From: Clare Sutton (MHA) [REDACTED]
Sent: 12 September 2018 15:57
To: Richard Castro-Parker
Cc: Juan Baeza; Mark Coates; Nat King-Smith (MHA)
Subject: RE: New Parking Scheme re: 1-7 Canada Road ref: AB/4/18/PL

Subject: FW: New Parking Scheme re: 1-7 Canada Road ref: AB/4/18/PL

Site Plan 1:200

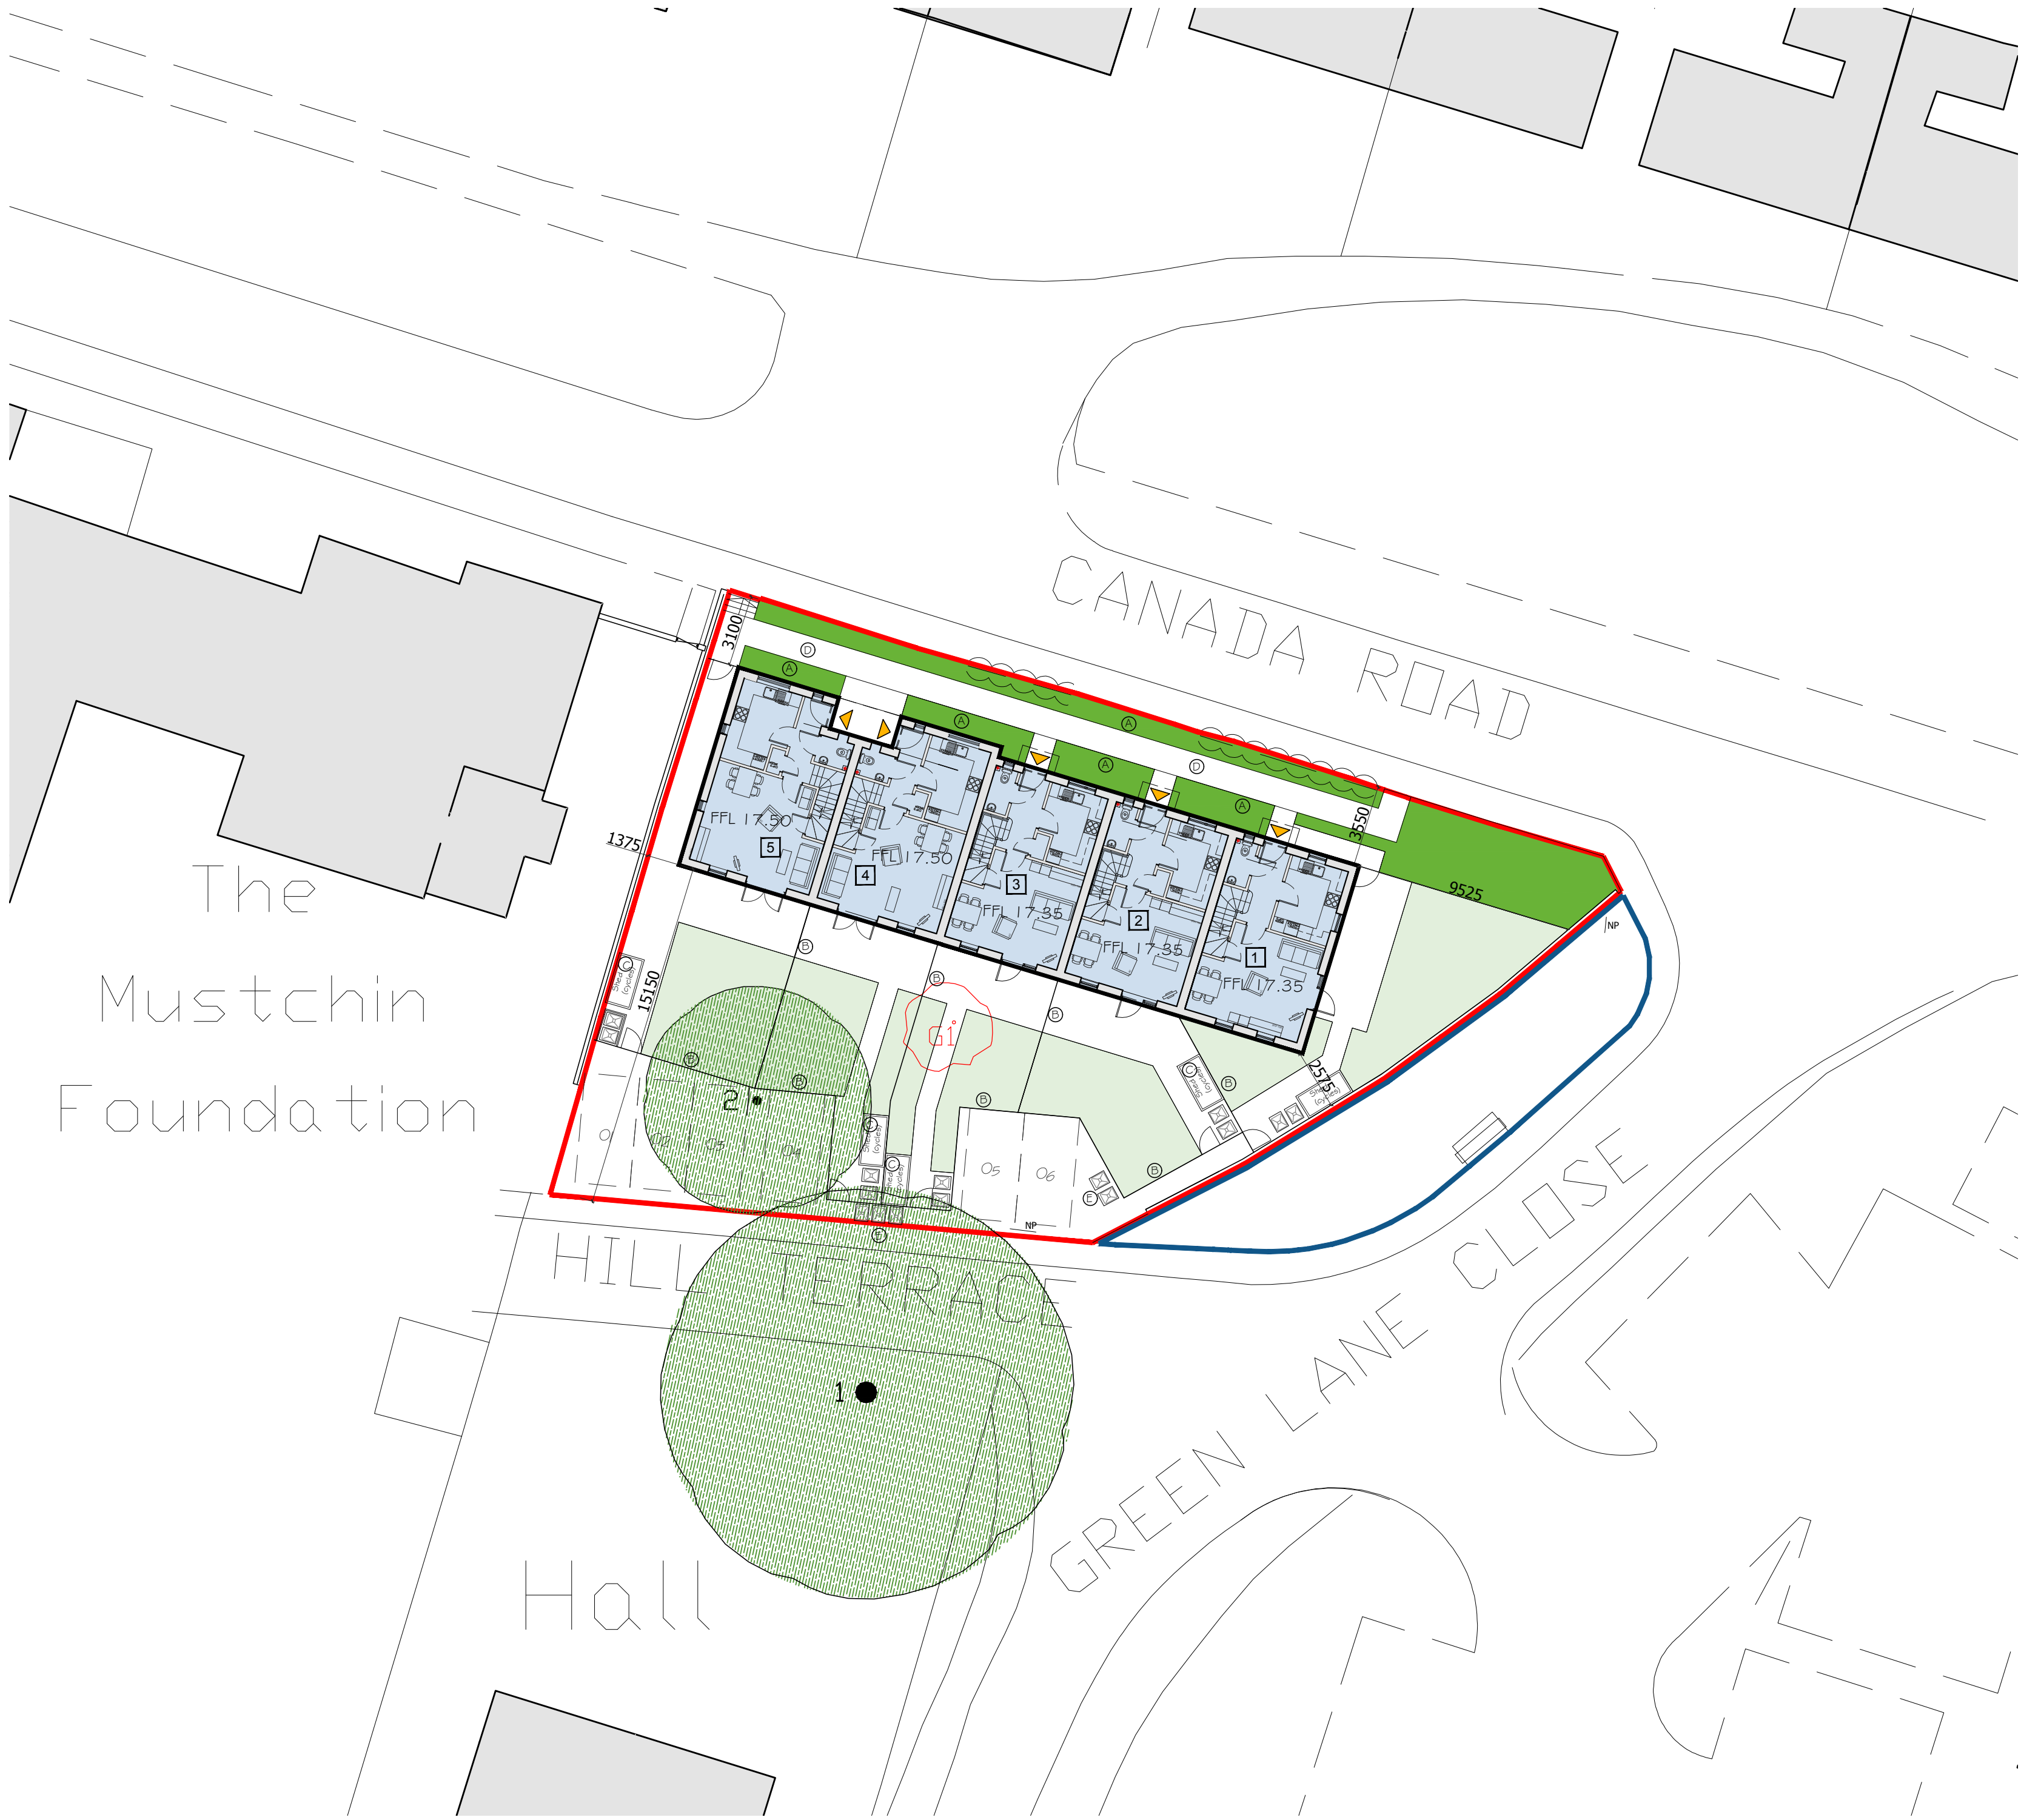
Parking will be provided in 2 locations. A layby arrangement will be created on Canada Road to provide 5 parallel spaces. An off street space will be created via Hill Terrace to serve plot 1.

I note the site plan provided annotates areas 'owned' by WSCC. This is not strictly true as the areas indicated as considered 'adopted public highway' and not 'owned' by WSCC.

The layby arrangement will require land consider public highway and thus the spaces created could not be reserved for use specific use by residents of the proposed units. I note a slither at the southern extent of these spaces is not adopted highway.

Is it intended to have the areas of public highway within then layby 'Stopped Up', spaces could then be used specifically for residents of the proposed units, or will its status as public highway remain? If it is to remain as public highway will the slither of land be put up for adoption under a Section 38 Agreement?

Is it intended that the relocated footway will be offered for adoption under a Section 38 agreement? Ideally any newly created footways should be a minimum of 2.0 metres in width, this does not seem to meet this minimum width.

There is a question if the highway works should also be subject to a Stage 1 Road Safety Audit, presumably this has not been done given the change is quite recent. If you can look into the matters above regarding the applicants intentions over the layby and footway status I will consult this end and see if the works should be subject to a Safety Audit.

The annotation regarding 'ownership' was in relation to the notice that was required to be served to WSCC highways as this area of land is not owned by Arun District Council.

It is not proposed that the parking is for the sole use of residents of the proposed units. The spaces in the layby are indicated on the drawing as unallocated.

Both the 'slither' of land in the laybys and the footpath will be offered for adoption under a section 38 agreement.

The proposed footpath is 1800mm wide and will replace the current footpath which varies between 1400mm and 1650mm wide. It will connect to the existing footpath in front of the Mustchin Foundation which is approximately 1800mm wide. If necessary we will amend the site plan to increase the footpath to 2m.

If a stage 1 road safety audit is required we will commission one but I would note that currently cars can park on both sides of this narrow road - see attached photo courtesy of google maps and that the addition of the layby, increasing the width, should improve the safety.
